## About the application

Application number: 2023/93587	
What is the application for?:	Erection of two dwellings
Address of the site or building:	adj, 93a, Halifax Road, Hightown, Liversedge, WF15 6PP
Postcode:

Site Plan As Proposed  
 Scale 1:100

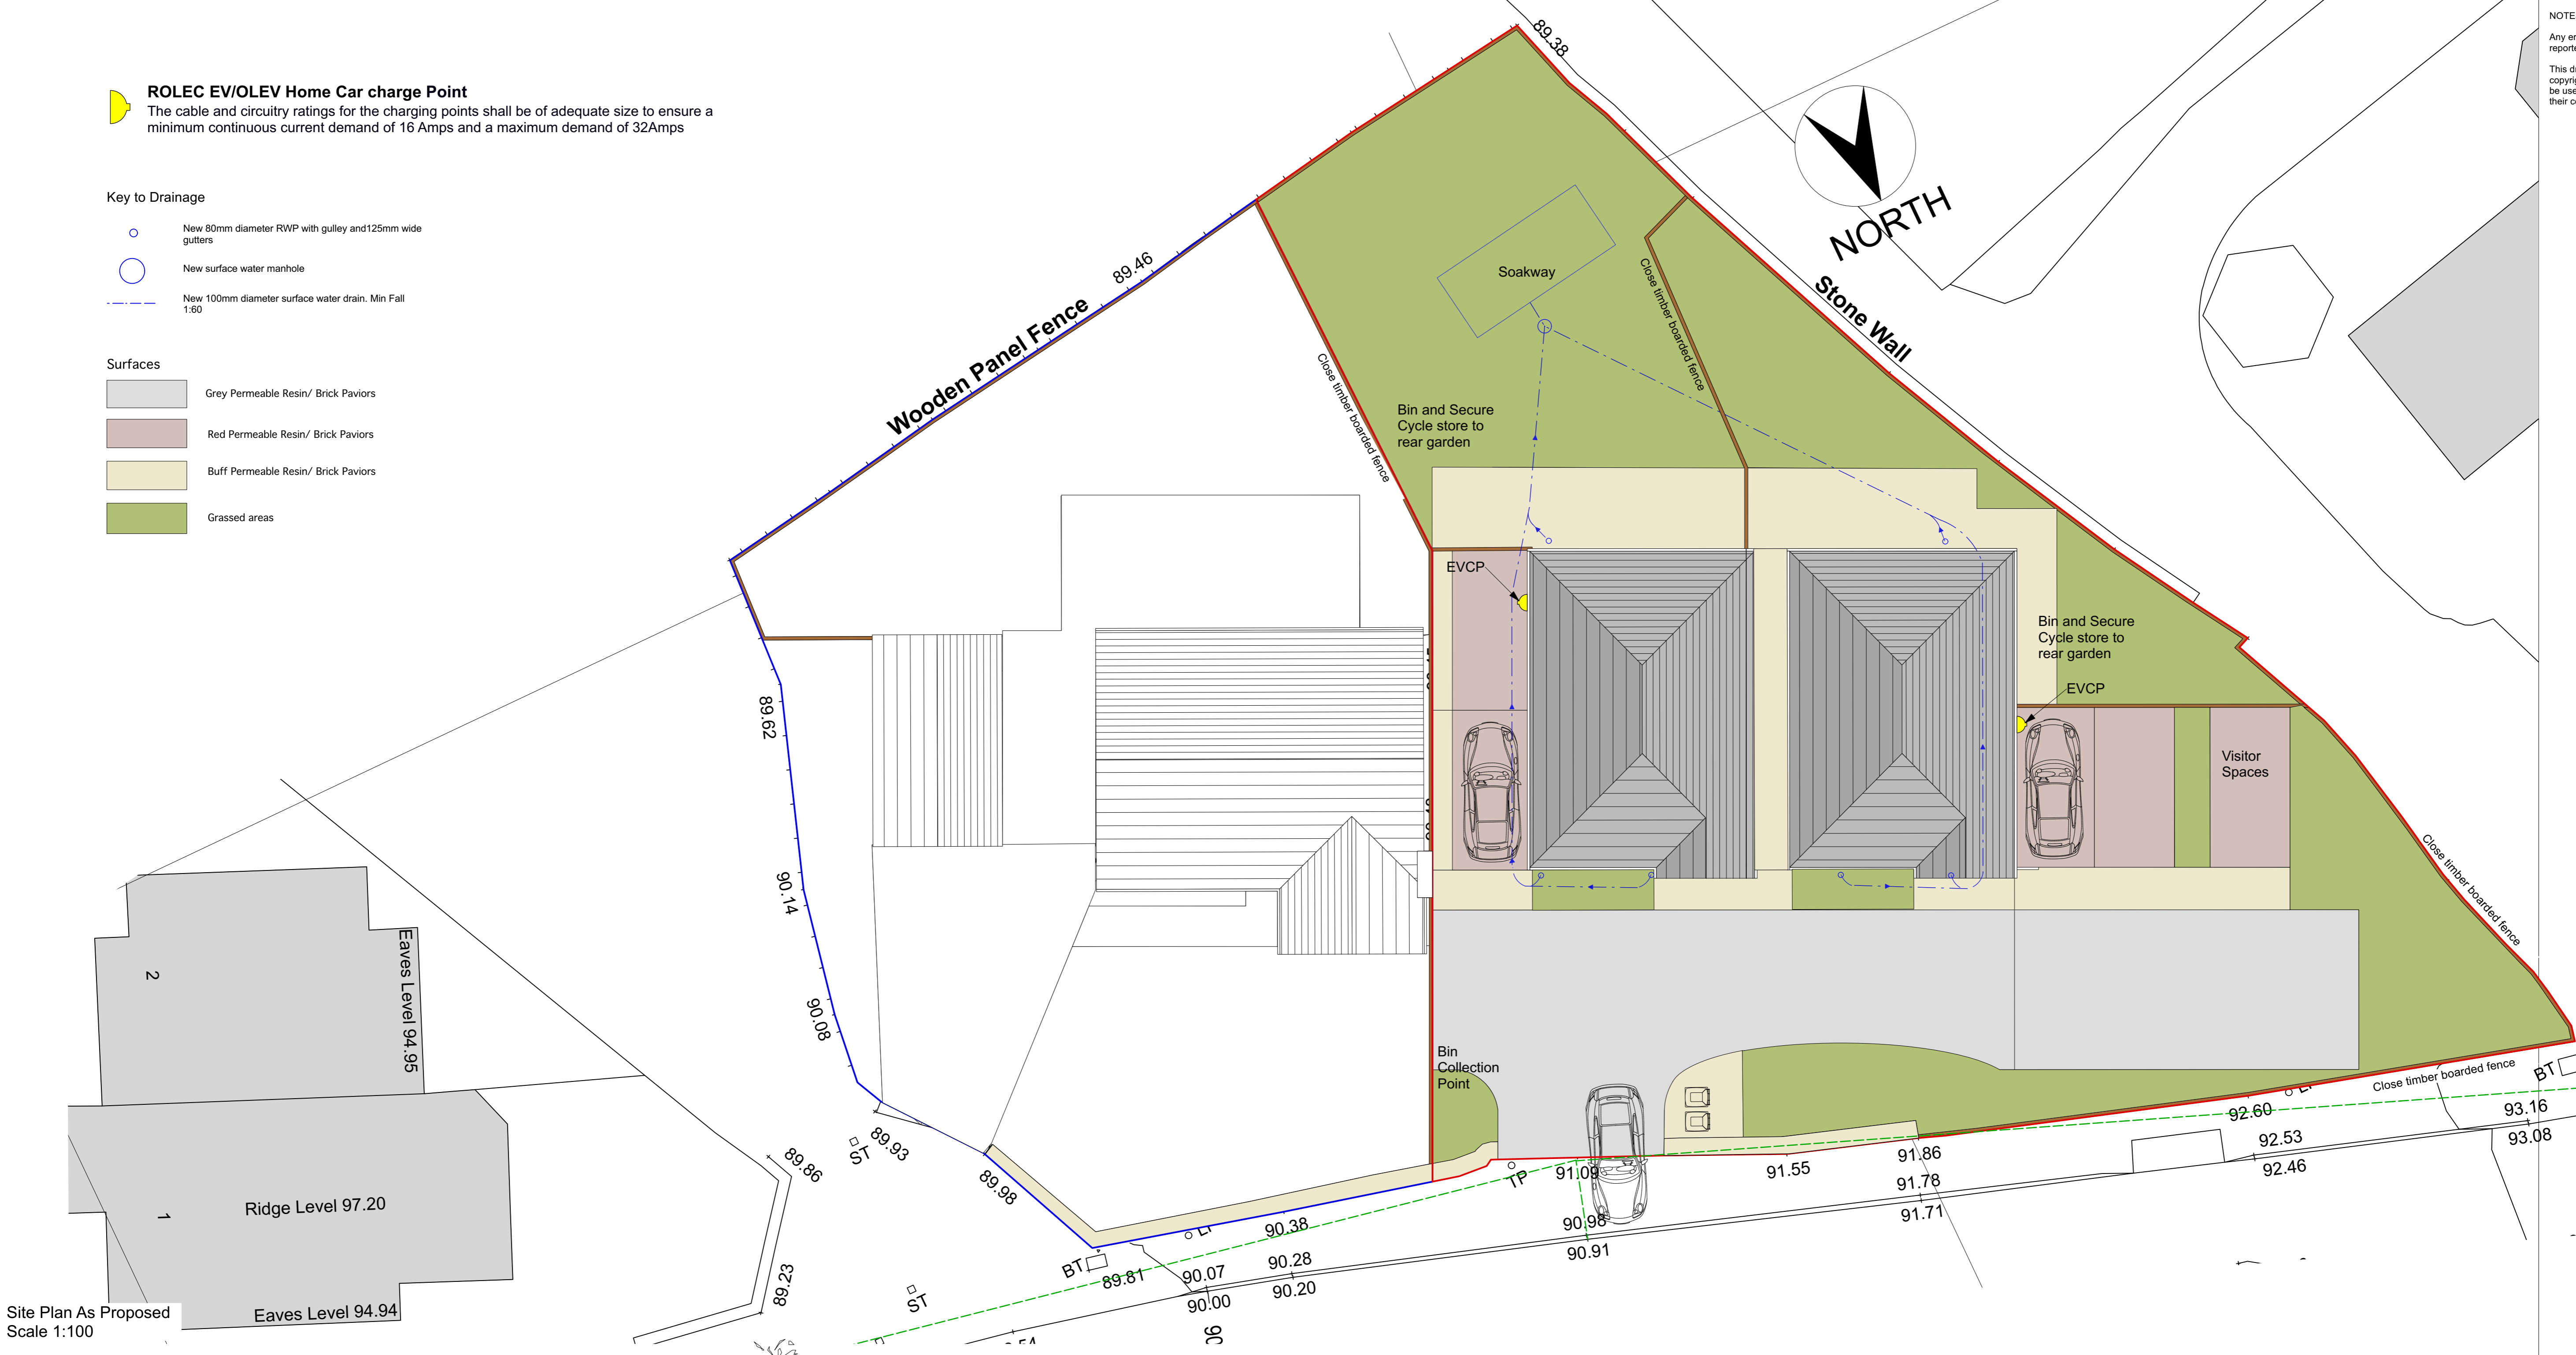
Type of comment: A general comment	
Do you wish your comments to be published on the website anonymously?	Yes
We would ask that whatever boundry is at the north west corner of the plot at the junction of Prospect Terrace and Halifax Road be designed to give a driver exiting from Prospect Terrace to have a clear safe view of oncoming traffic from the right along Halifax road.
